COMMUNITY DEVELOPMENT DEPARTMENT
501 Delta Avenue ♦ Marysville, WA 98270 ♦ (360) 363-8000

September 1, 2023

Re: M-51 Industrial – *Technical Review 1*
PA 23014

A PORTION OF THE NW 1/4, SW 1/4, SEC 27, TWN 31 N, RGE 5 E, W.M. CITY OF MARYSVILLE, SNOHOMISH COUNTY, WASHINGTON

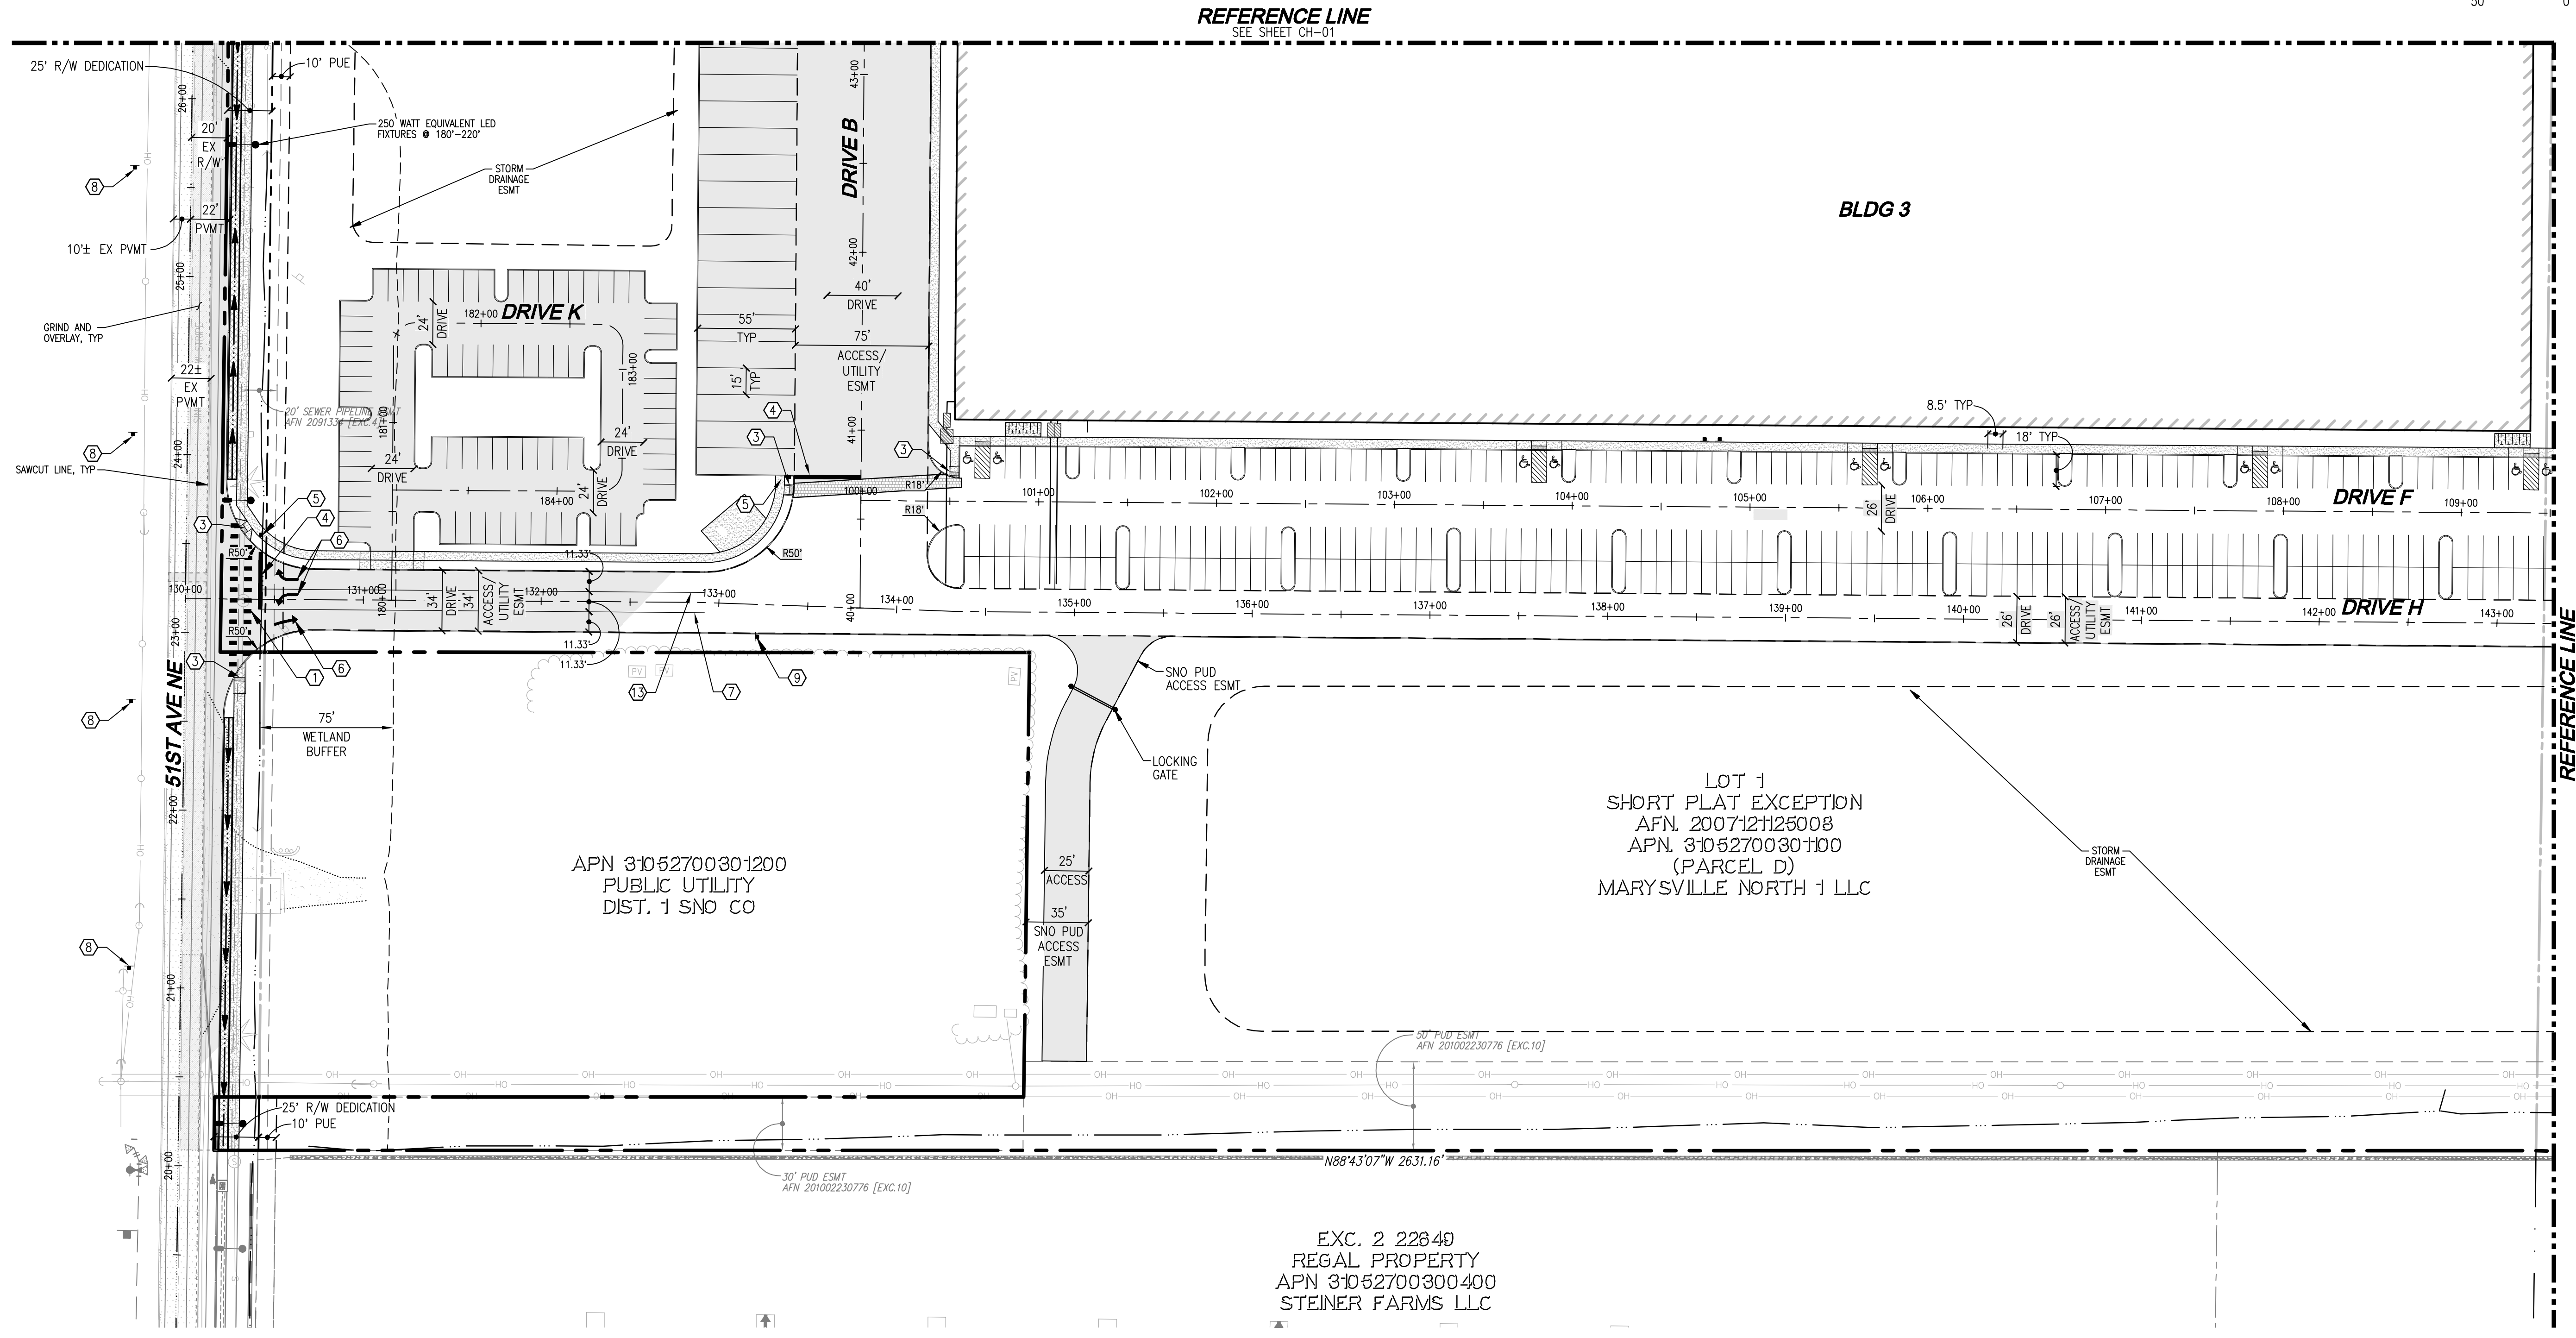
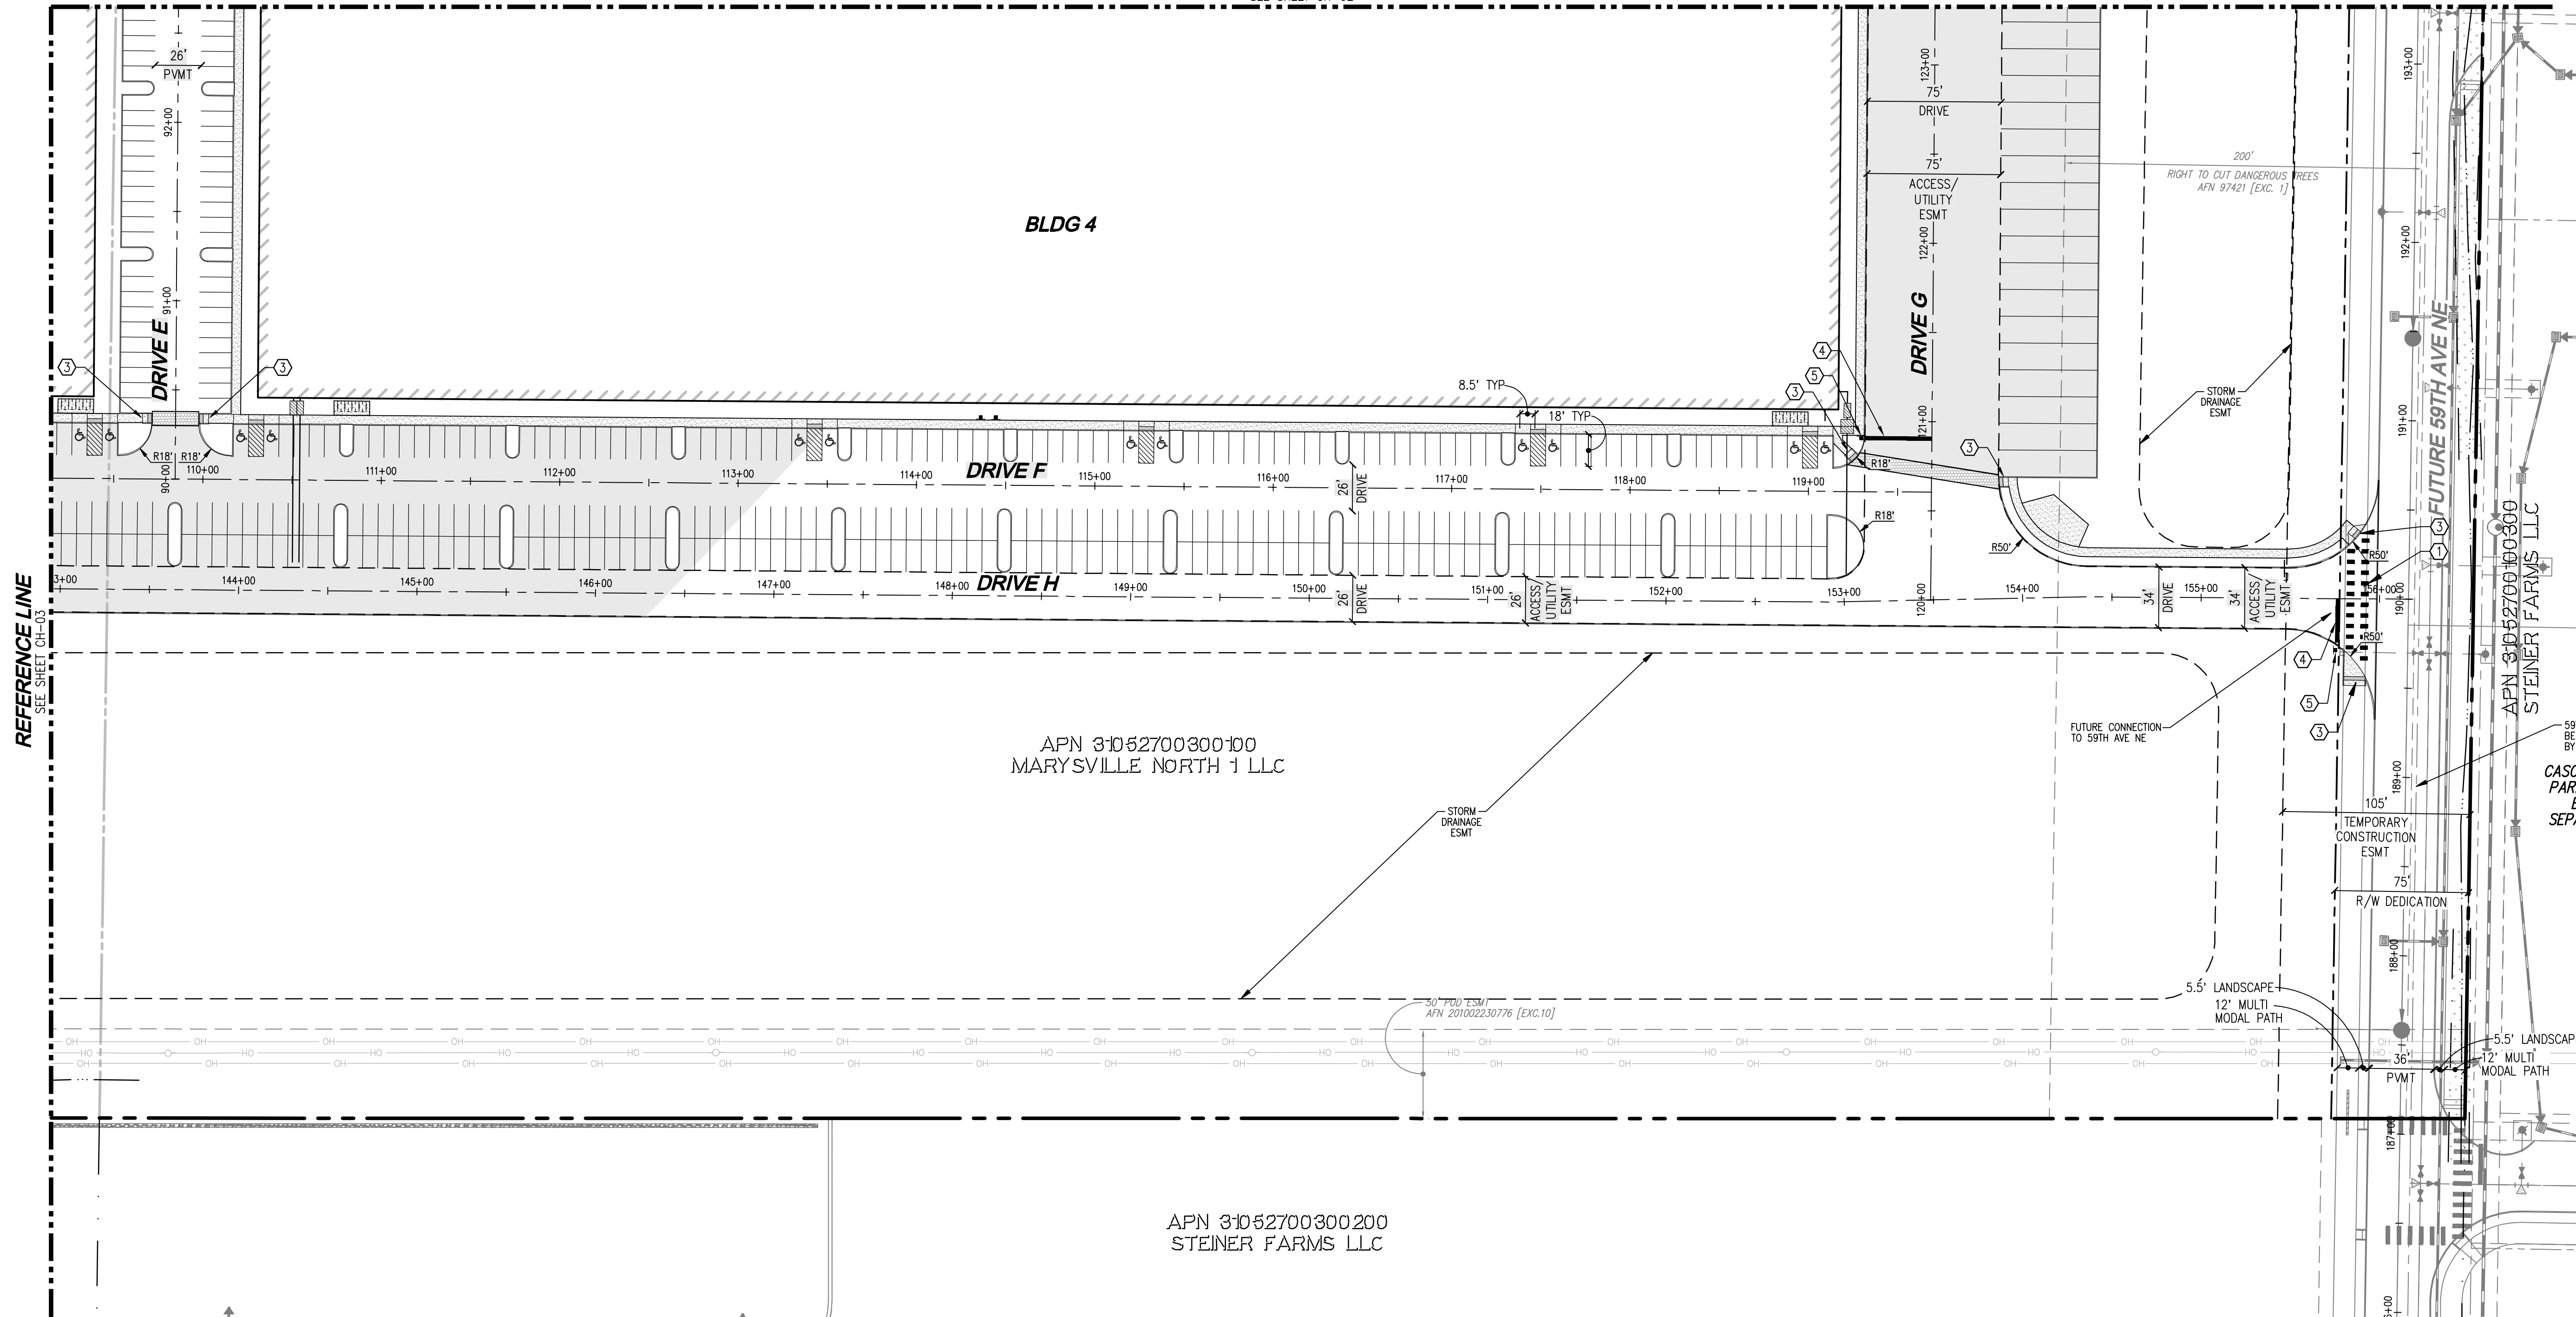
37. Per EDDS 3-506, street lighting will be required.
 - a. Street Lighting upon 51st Ave NE and 59th Ave NE shall be PUD installed fiberglass pole installation type street lighting.

- i. Street lighting shall be designed as minor arterial utilizing 250 watt equivalent LED fixtures.
 - ii. Spacing of fixtures should be approximately 180'-220'.

- iv. Contact Eddie Haugen of Snohomish County PUD at (425) 783-8276 or wehaugen@snopud.com for more information regarding PUD design.
38. Signing and Channelization Plans shall be required as part of Civil Construction plans.
